From: Harry Chalk
Sent: 02 June 2025 09:55
To: Planning Scanning
Subject: FW: WA/27/25/PL - Stoney Brook Farm

From: Harry Chalk <Harry.Chalk@arun.gov.uk>
Date: Wednesday, 30 April 2025 at 15:40
To: Max Short <[REDACTED]>
Subject: WA/27/25/PL - Stoney Brook Farm

Project: STONE BROOK FARM Eastergate Lane, Walberton, Arundel, BN18 0BA	
Drawing Title: Proposed Floor Plan DWG 3	
Scale: 1:50	Sheet:
Drawn by: Samuel Byrne	Date: 9.10.2024
Sheet No.:	Revision:

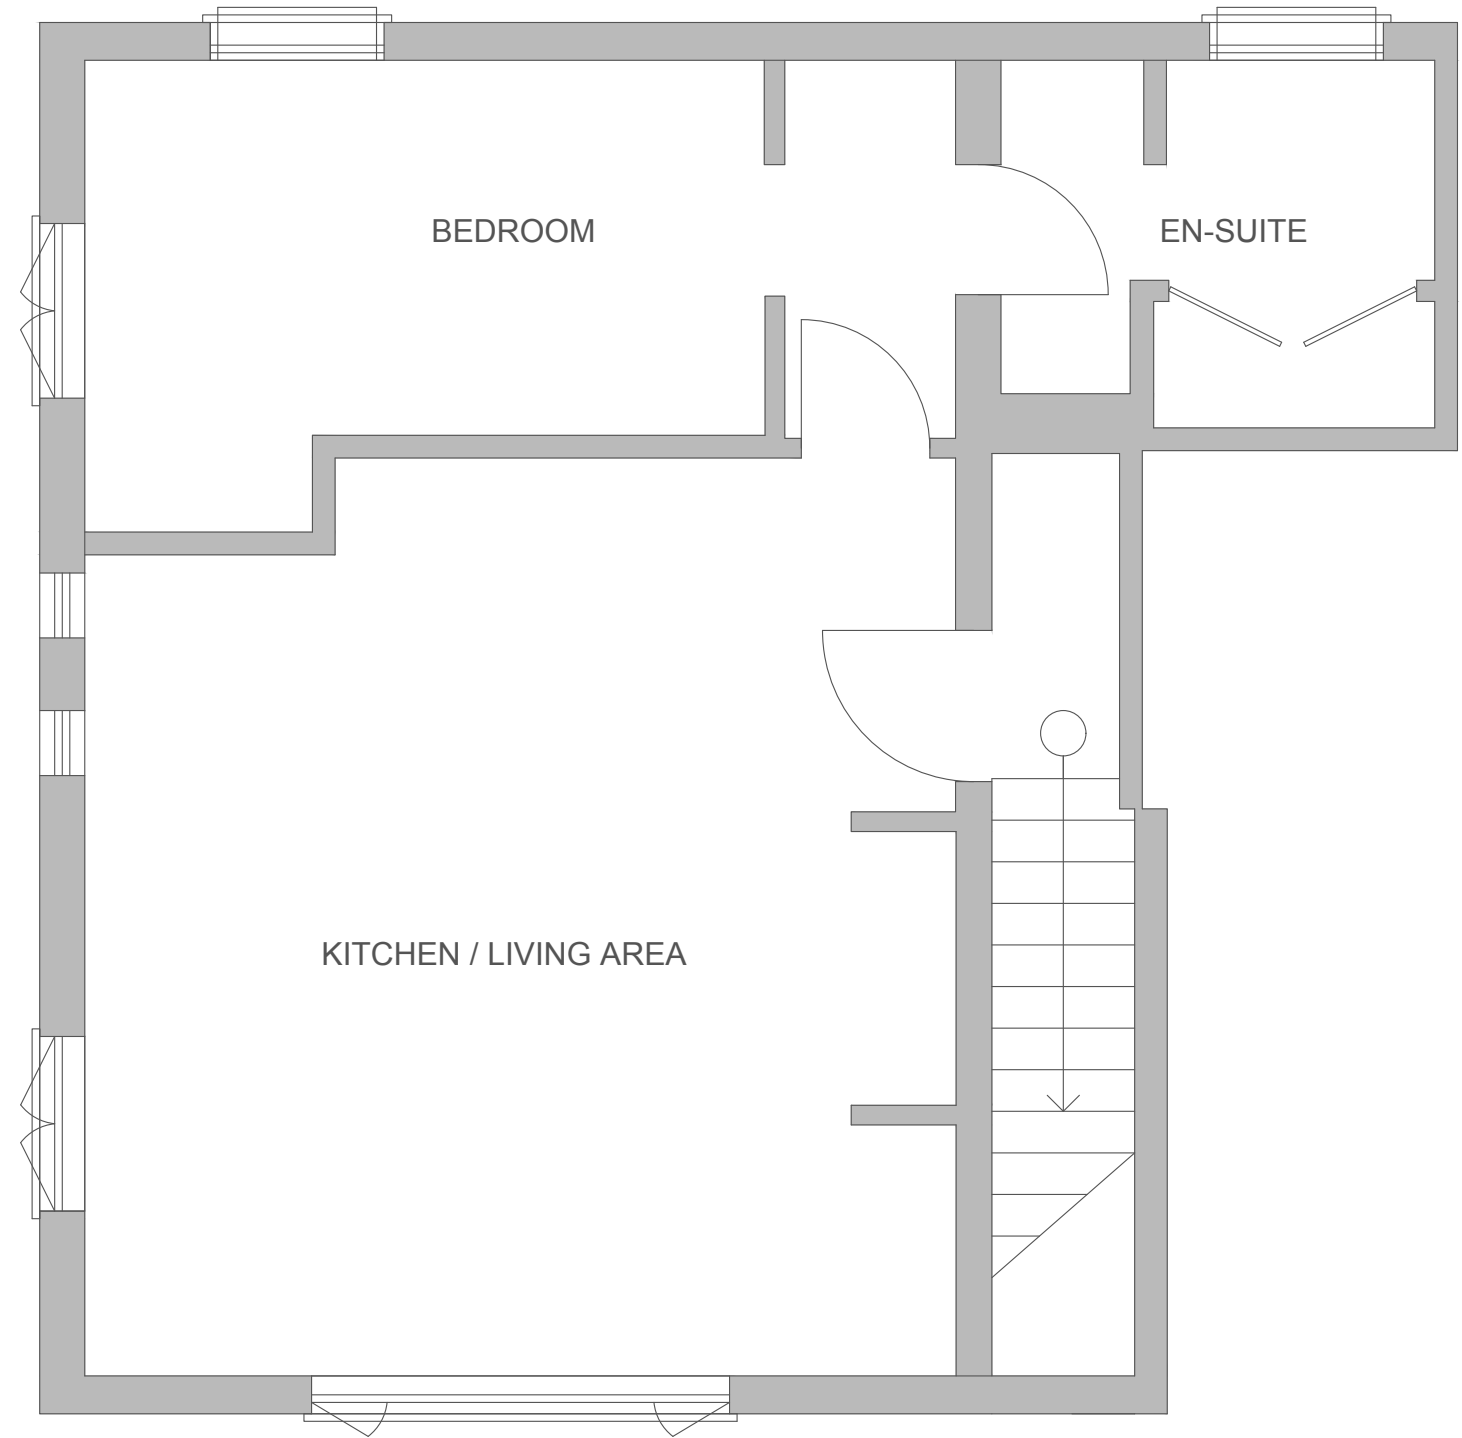
I note the absence of any proposed cycle parking provisions for the proposed unit. There is limited space in and around the site within the red edge for cycle storage. Could you confirm whether such a unit could be secured by way of condition on the hardstanding to the south of the proposed unit, or at another location within the red edge, without interfering with access requirements for adjacent buildings?

I have noticed that the proposed site plan seems to propose a car parking space on the southern side of the proposed dwelling that would prevent access further south into the site. However, from remote imaging, the existing hardstanding appears wider and as such, the designated parking space area would not prevent access further south into the site, rather sit alongside it.

Could you confirm my suspicion about the existing hardstanding and that the proposal would not be preventing access further south into the site? An amended site plan should be submitted to this effect if I am correct. Please provide any necessary amendments to the site plan by 07/05/25.

Yes I can confirm this, although I think a condition would be best to deal with this point. We are expecting the application for the replacement workshop building (WA/108/24/PL) to be approved, meaning the workshop immediately to the south of the building will be removed and no longer needing access. If not, there are other options on the site for cycle storage which can be explored if/when necessary.

I have looked into this and I can confirm your suspicion appears to be correct. An amended site plan is being prepared and I will forward as soon as possible.
